Please ask for: Ms Iqraa Malik
Email: iqraa.malik@terraquest.co.uk
Telephone: 0121 234 1390
Our Ref: Y/134/21/HH
Your Ref:
Date: 17th September 2021

Application for Planning Permission for Works or Extension to a Dwelling

Development: Single storey, part two storey rear extension
Location: 3 Cherry Avenue Yapton BN18 0LB

Drawing Proposed Alterations and Extension
Existing Plans

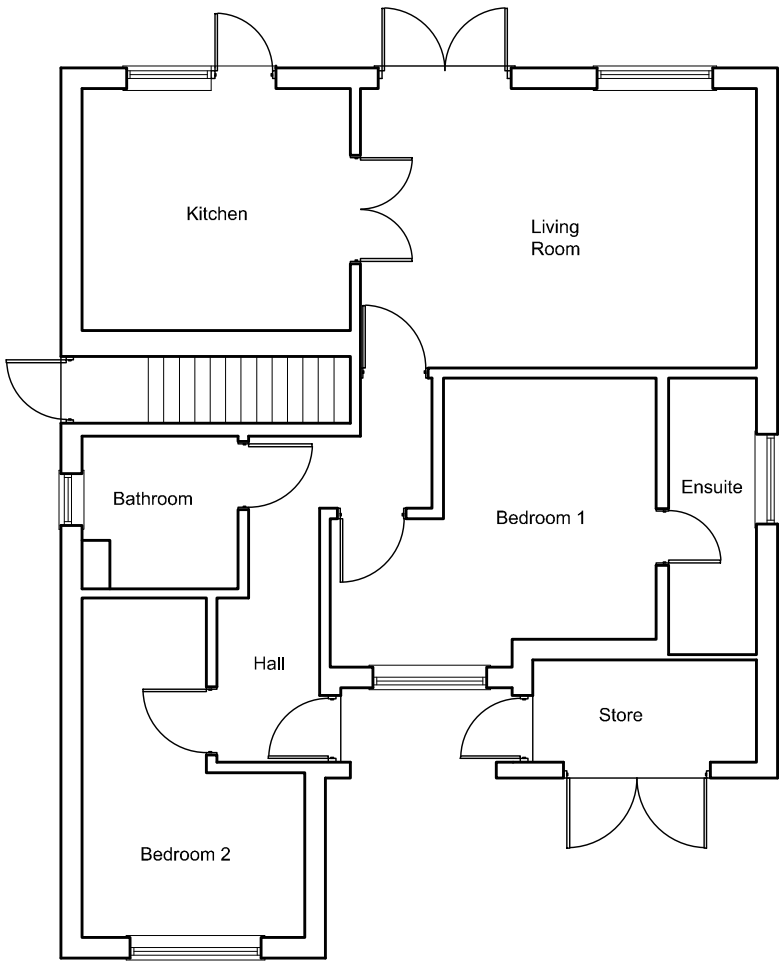
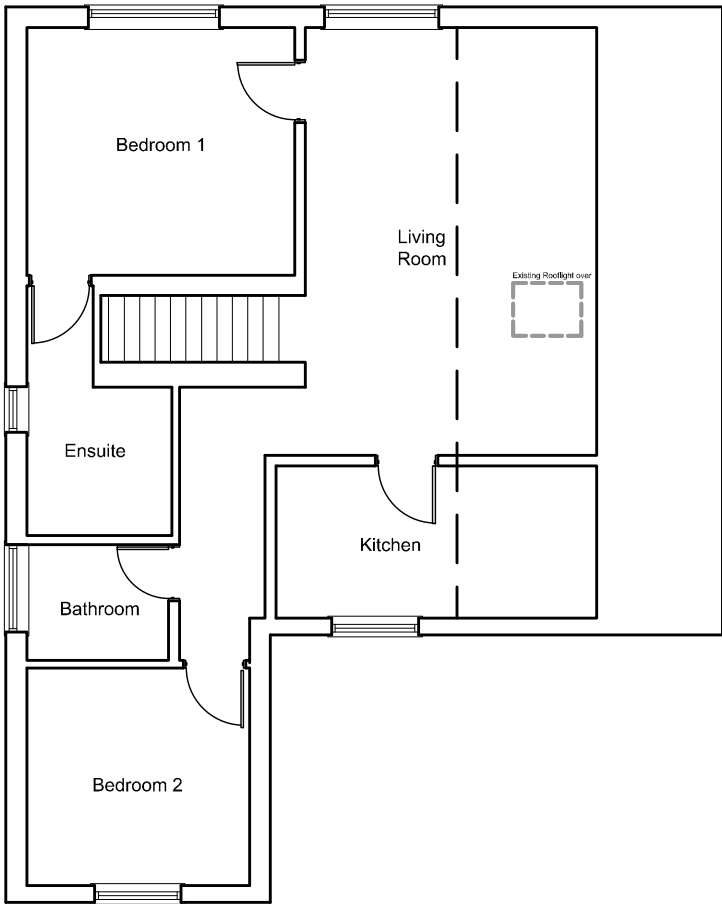
The existing ground and first floor plans are labelled wrong. Along with this, the existing rooflight is missing from the existing first floor plan. Please review and amend.

Drawing **Proposed Alterations and Extension
Proposed Elevations**

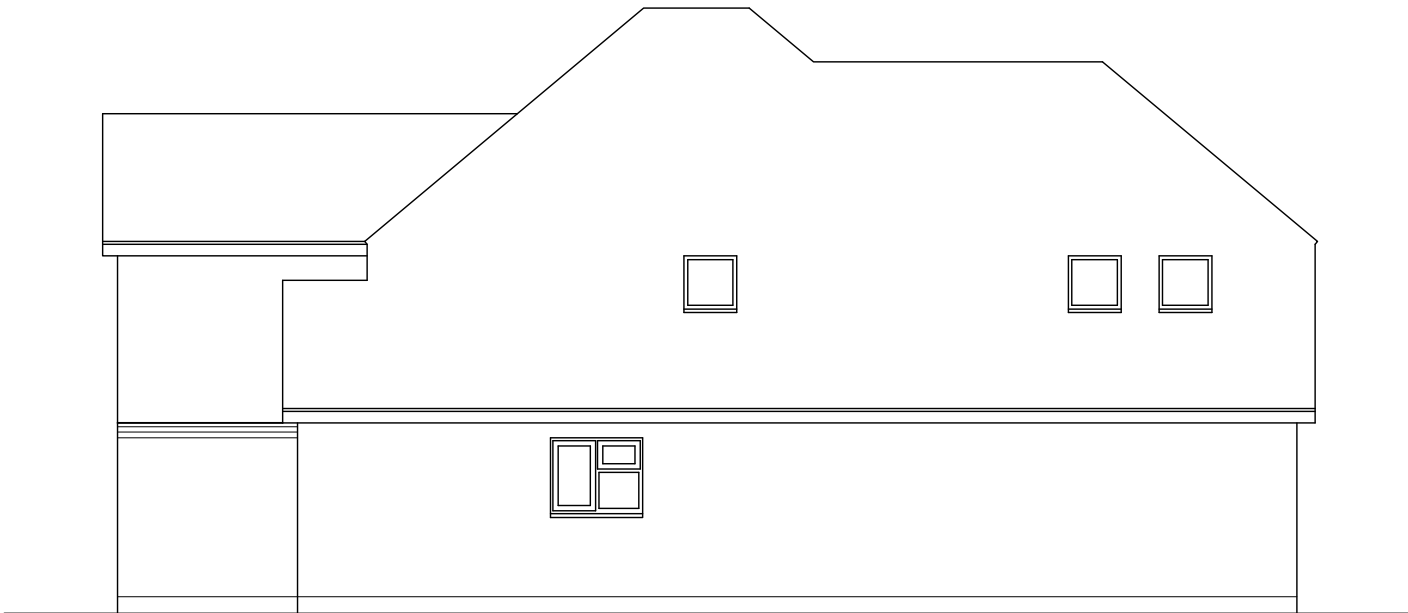
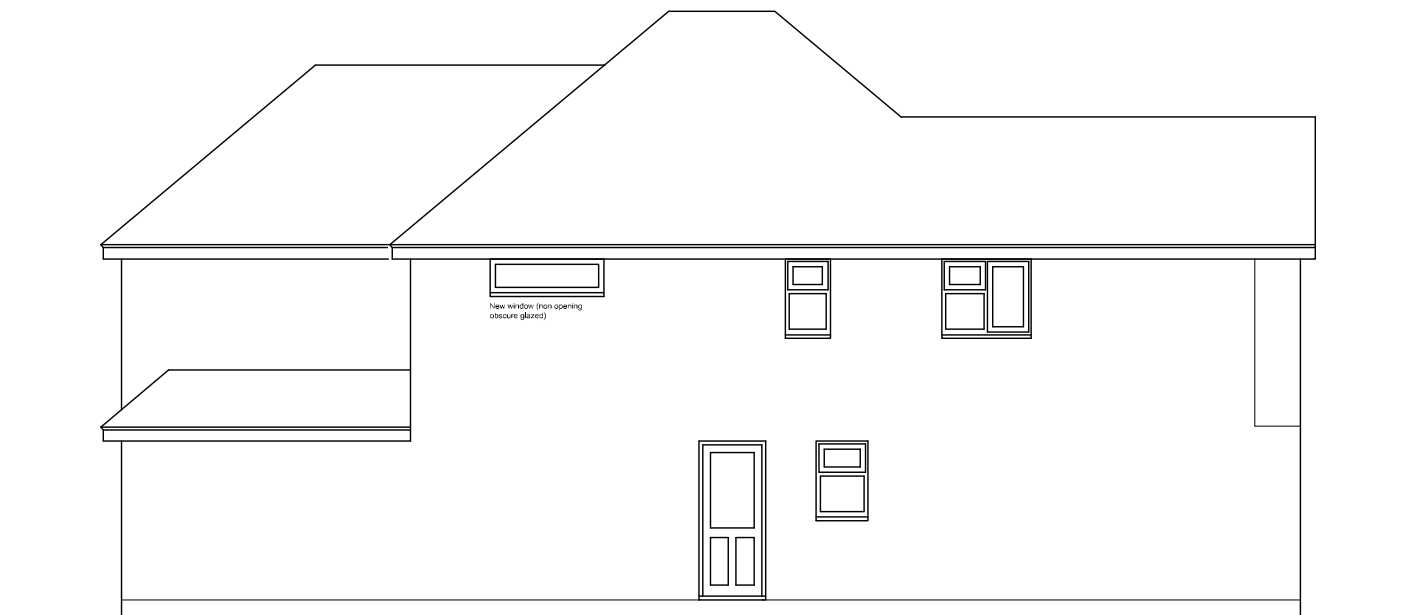
The new bedroom window on the proposed first floor plan is missing from the north east elevation. Please amend.
